From: John Macholc
Sent: 21 May 2015 15:39
To: Jane Tucker
Subject: FW: Discharge of condition 34 Kirklands chipping

Subject: Discharge of condition 34 Kirklands chipping

Client:	KEEPMOAT		
Job:	KIRKLANDS, CHIPPING		
Drawing title:	SITE LAYOUT		
Drawing Number: (Job number)	M3792	100	Revision: C
Scale:	1:100@A1		
Date:	FEB 15		
Drawn by/ checked by:	MCS

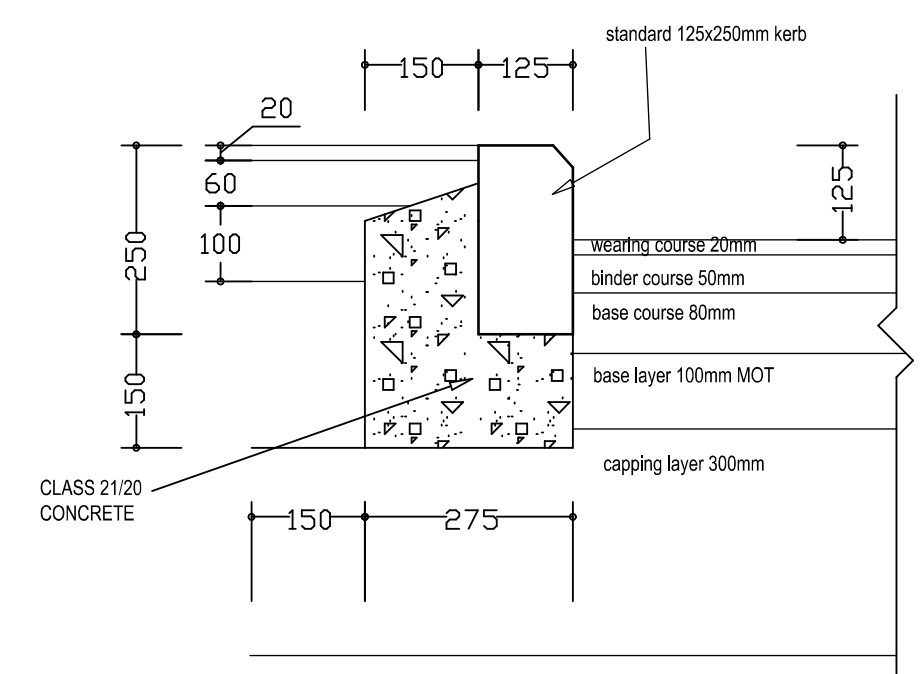
Thankyou for the further details. Have you submitted the revised parking layout?

Revised site and landscape layouts amended to suit the comments regarding parking to 34 Kirklands & visibility splay issues and the disabled parking provision and reversing space should the user park over the hatched markings, I trust that these answer your query to your satisfaction.

With regards the parking indicated to 14 Club View, this is outside our site area and the hatching was intended to indicate the area of making good we anticipated needing doing following the construction of the fence lines and retaining structures, it's currently used by this occupant and isn't actually a space designated by ourselves, we've removed the hatch to avoid confusion.

Client:	KEEPMOAT		
Job:	KIRKLANDS, CHIPPING		
Drawing title:	SITE LAYOUT		
Drawing Number: (Job number)	M3792	100	Revision: E
Scale:	1:100@A1		
Date:	FEB 15		
Drawn by/ checked by:	MCS

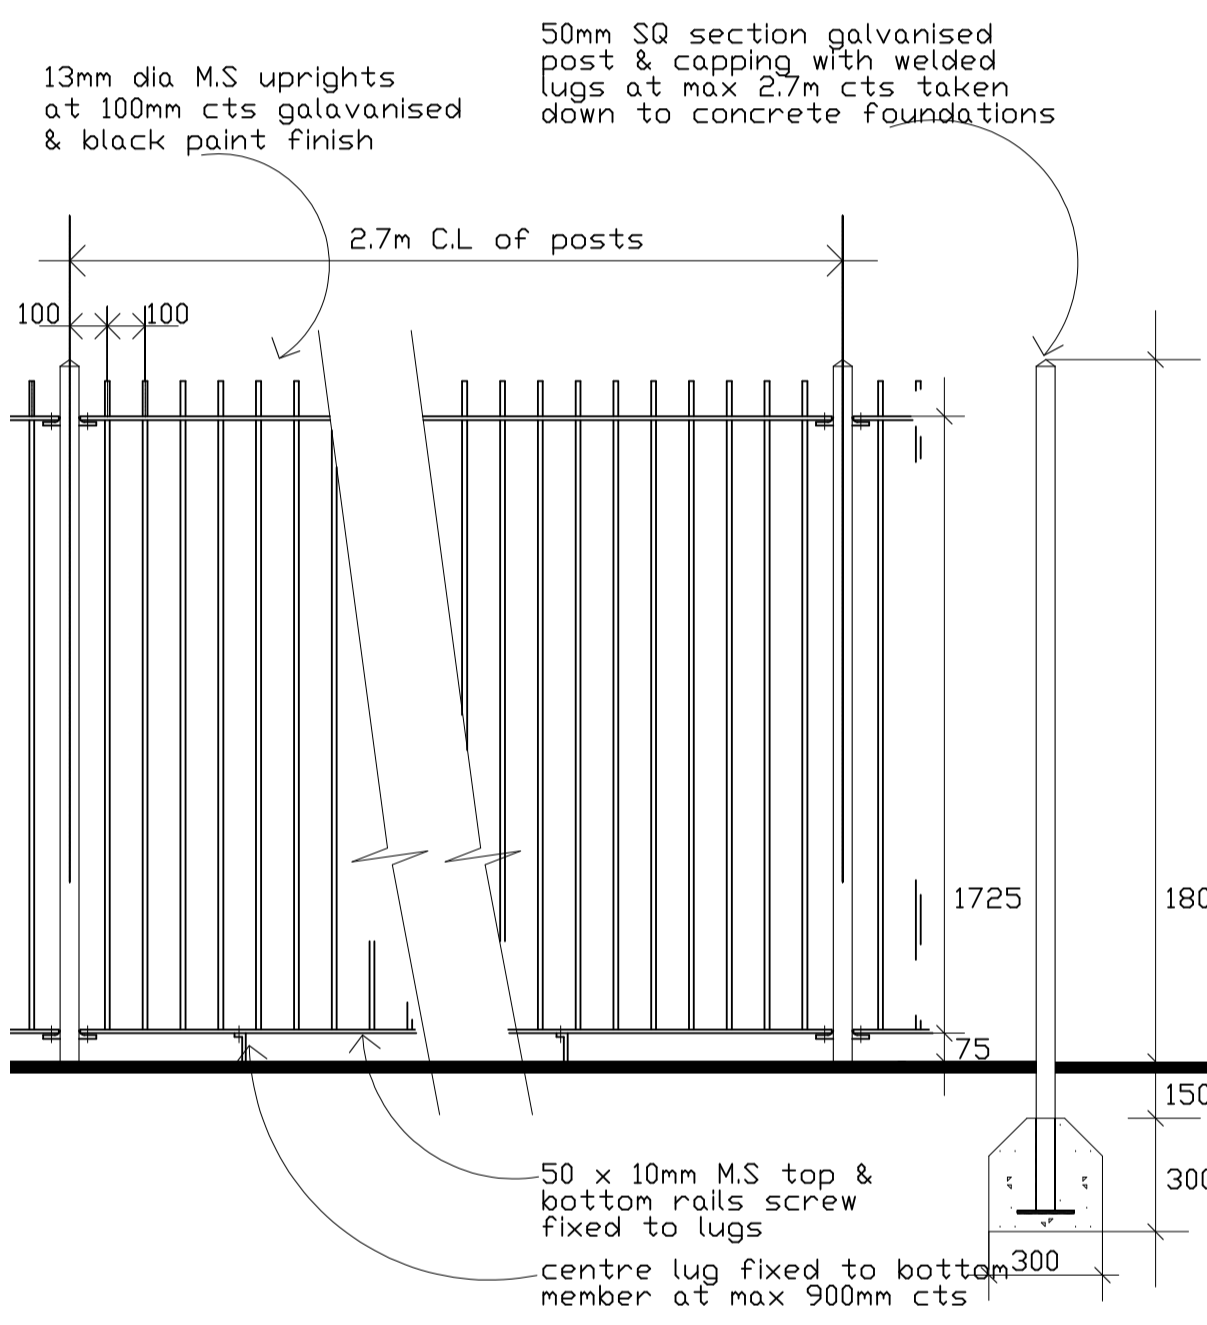
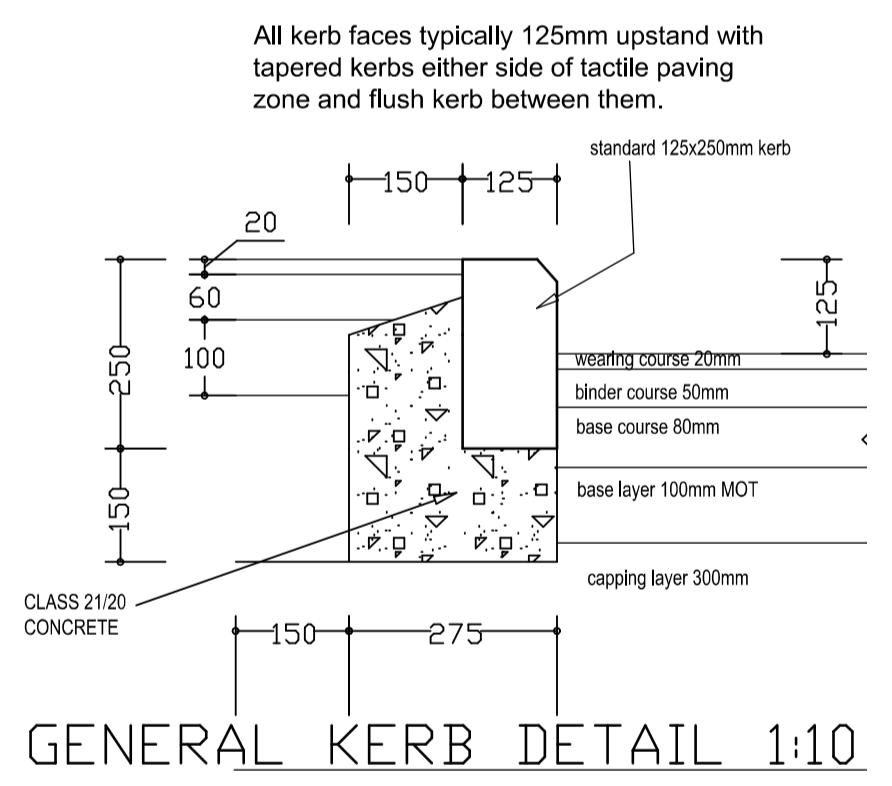
Can I suggest you contact Stewart direct and get back to me. If you are unable to amend please advise. As the application date expires on Tuesday it is my intention to discharge other conditions such as materials, landscaping and renewable energy and you will have to resubmit the highway condition unless you can resolve it by tomorrow morning. I will keep hold of the NMA on the basis that you secure a revised site plan.

Afternoon Mike,
The revised plan is acceptable.

Please find enclosed our revised site layout amended to reflect your comments received via John today, could you please have a look at and let me know today whether you are happy with the revised proposals, I also enclose your letter which we have added comments as before in red. Any query please feel free to contact me or my colleague Ruth Walker at the details below. Please note this is urgent as we want all conditions dealt with in the same application, we have had this with the planning department since end of March.
